**KIRKLEES METROPOLITAN COUNCIL  
TOWN AND COUNTRY PLANNING ACT 1990  
HIGHWAYS DEVELOPMENT CONTROL KP20H**

**PLANNING REF** 2016/62/91055/E0/SD  
**CATEGORY** Minor

**PROPOSAL** PART DEMOLITION, CONVERSION  
AND EXTENSION OF EXISTING  
BUILDINGS TO 9 RESIDENTIAL  
UNITS WITH ASSOCIATED CAR  
PARKING

**LOCATION** DENE BOTTOM,  
KIRKBURTON,  
HUDDERSFIELD,  
HD8 0PP

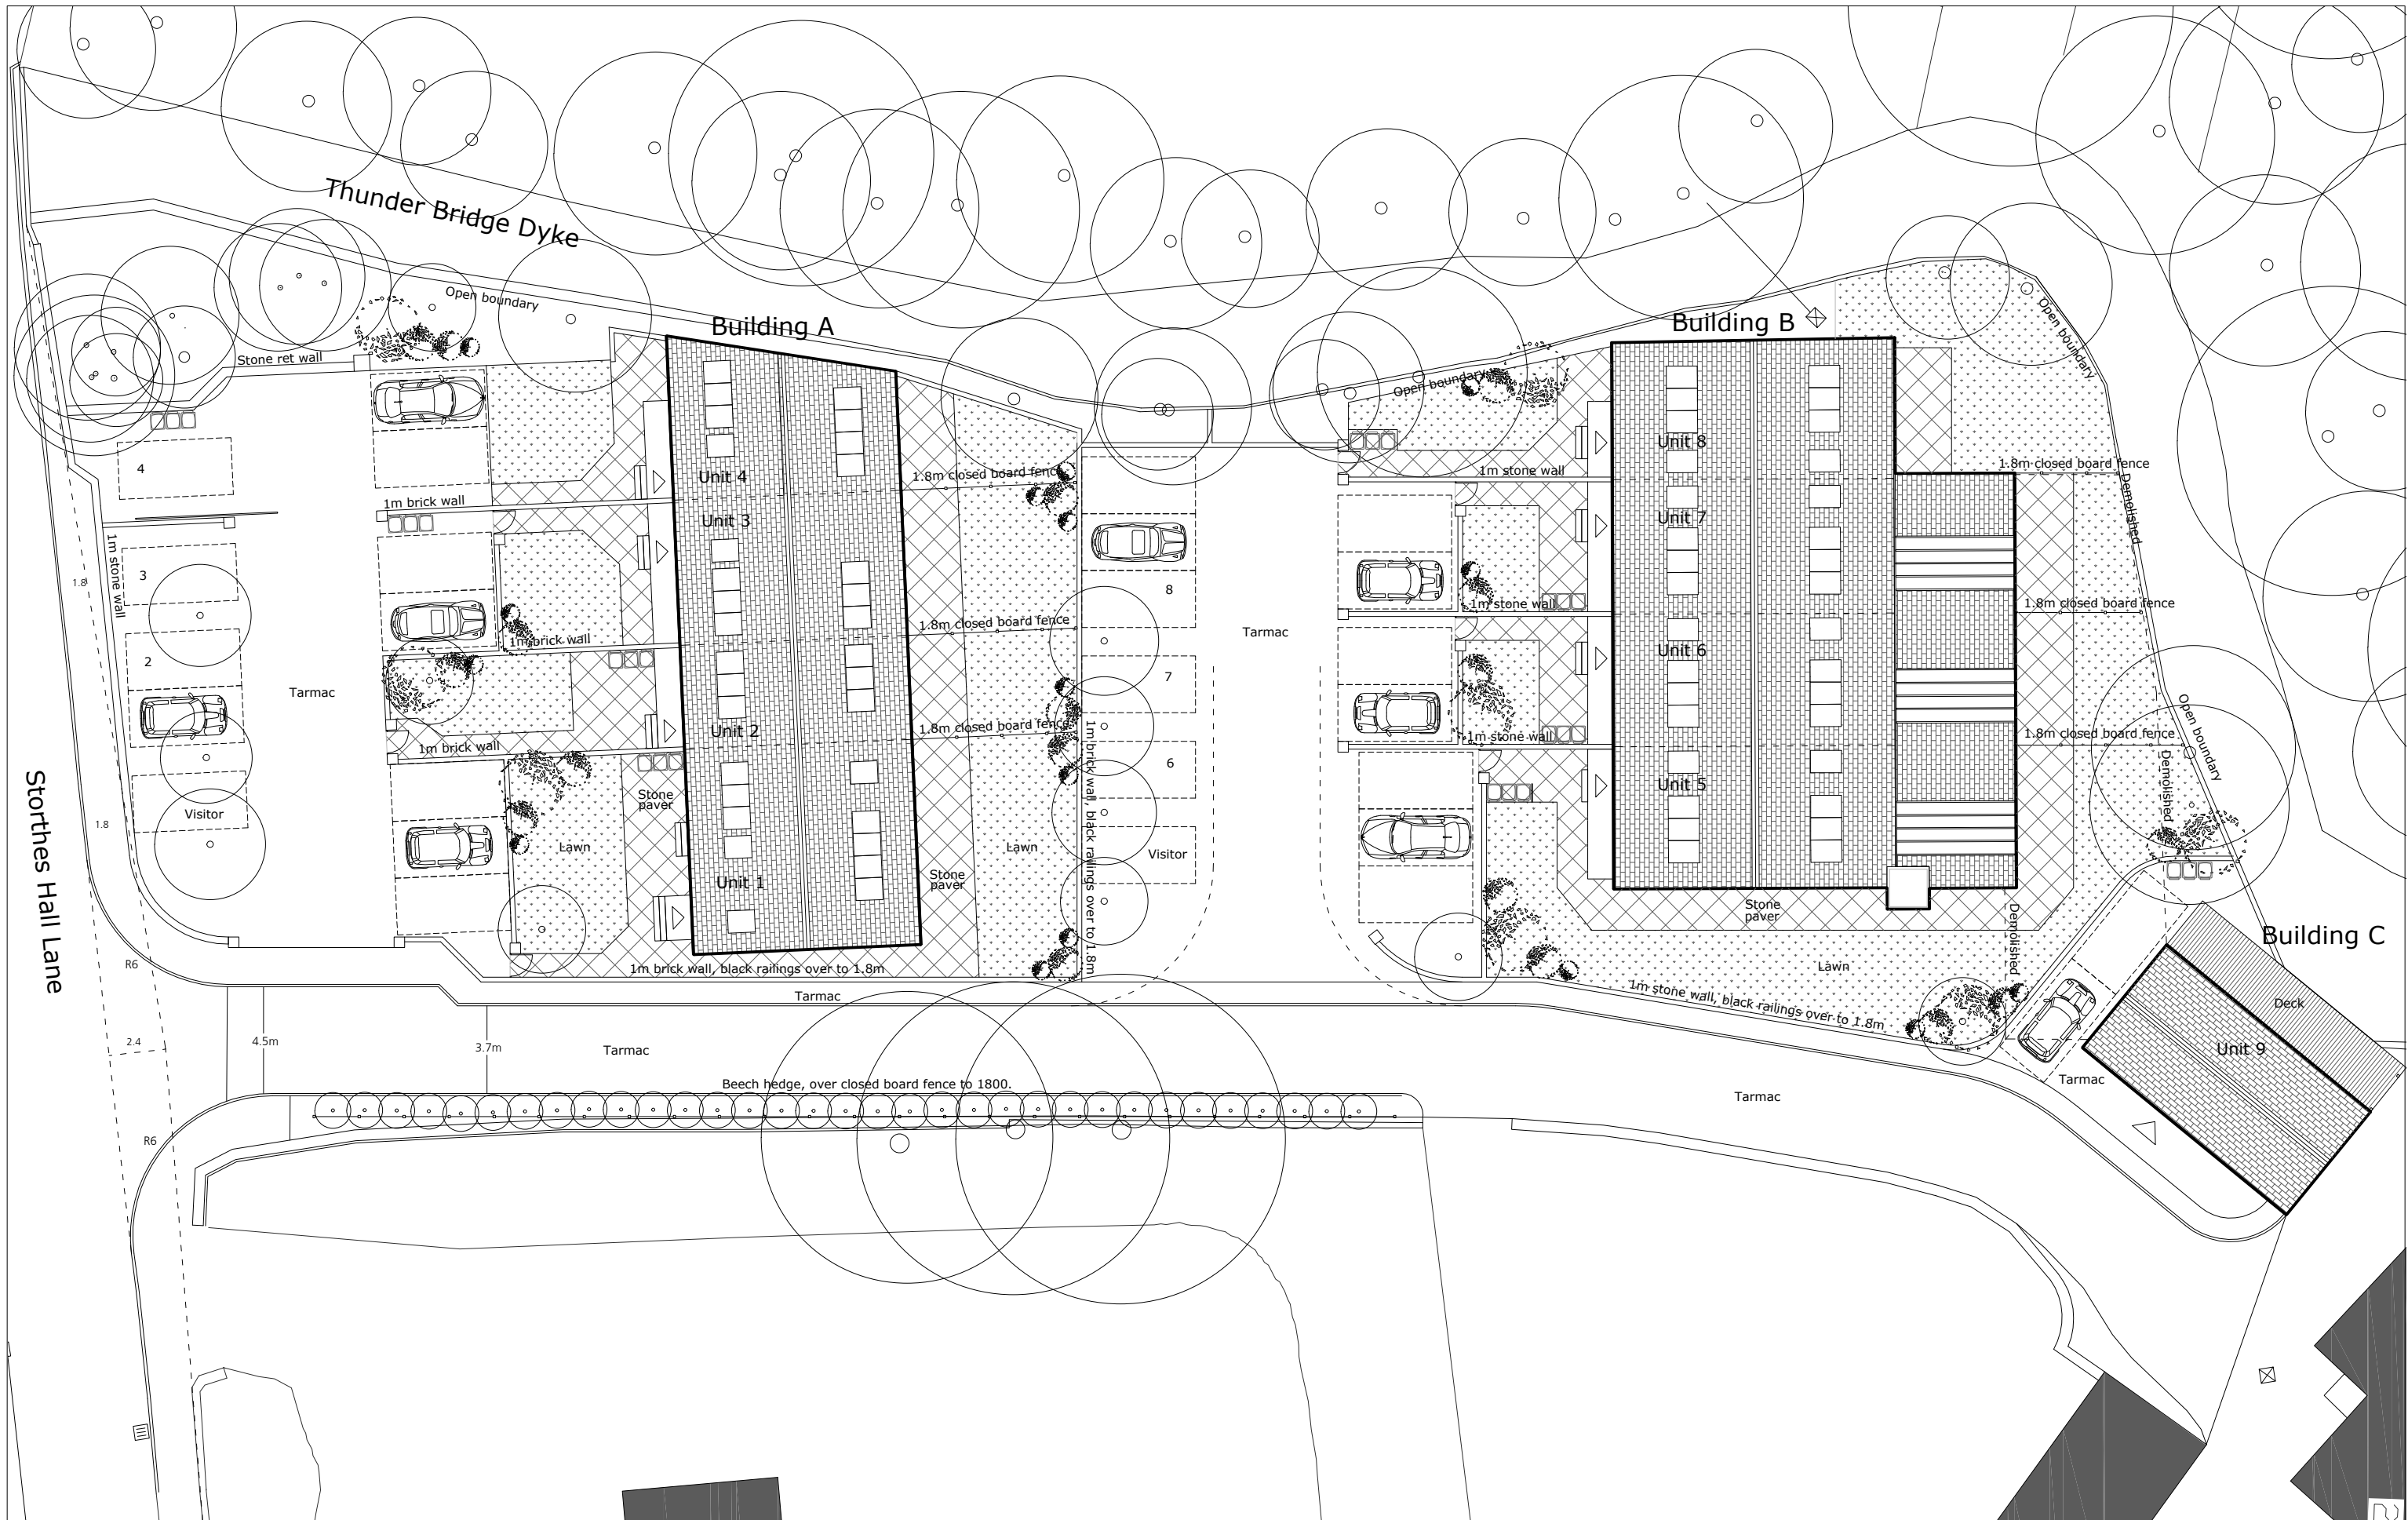
The dimensions of the proposed sight lines onto Storthes Hall Lane needed to be specified in both directions.

Given the number of dwellings the proposed access road should be constructed to adoptable standards. This would mean that 600mm hard margins are needed to all sections of any shared surface carriageways including the turning head which should be designed to accommodate the turning movements of an 11.6m refuse vehicle.

Whilst minor amendments may still need to be made to the design of the hard margins and a traffic calming ramp may be needed it is considered that these amendments could be required by condition and highways have therefore no wish to resist the granting of planning permission.

Prior to the development being brought into use, the sightlines of 2.4 m x 60m to the north east and 2.4 x 90m to the south west shall be cleared of all obstructions to visibility exceeding 1 m in height and these shall be retained free of any such obstruction.

The applicants have provided revised plan numbers p09 which shows:

Sight lines dimensions are specified

600mm hard margins to all sections of the shared surface carriageway including the turning head

The amended turning head is considered sufficient in size to accommodate an 11.6m refuse vehicle
